City of Portland, Maine - Building or Use Permit Application

Permit No: 03-0018	Issue Date: PERMIT ISSUED	CBL: 057 K009001
--------------------	----------------------------------	------------------

Location of Construction: 188 Danforth St	Owner Name: Thomsen Thomas W	Owner Address: 188 Danforth St	Phone: 207-774-9298
Business Name: n/a	Contractor Name: Woodward Thomsen Inc.	Contractor Address: PO Box 10359 Portland	Phone: 2077749298
Lessee/Buyer's Name n/a	Phone: n/a	Permit Type: Additions - Commercial	Zone: R-6

Proposed Use: Multi Family / Adding new window to east elevation and remove several interior particians (non load bearing)	Proposed Project Description: Adding new window to east elevation & remove interior walls.
--	---

# PARTIAL BASEMENT PLAN

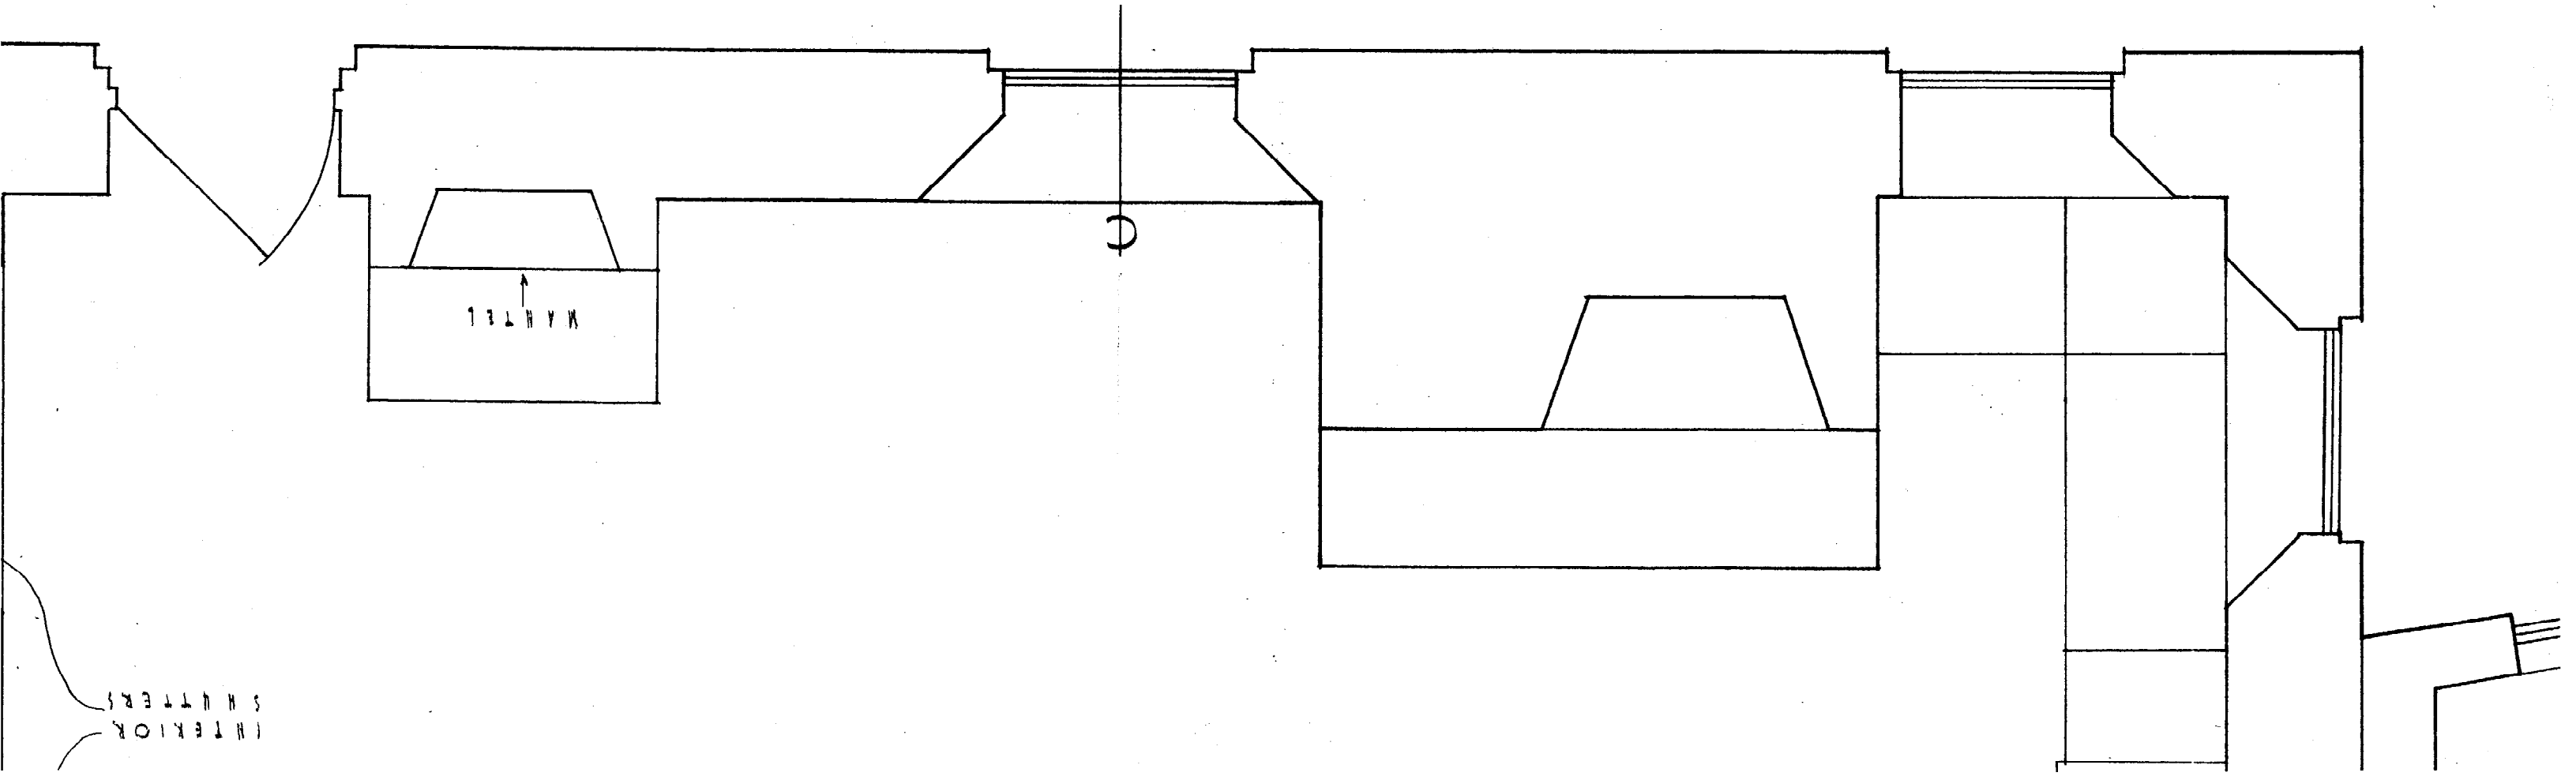
1/16/2003-mjn: need floor plans and header detail for window, left message for owner

- 1) Header is a granite lintle with steel reinforcement. MJN
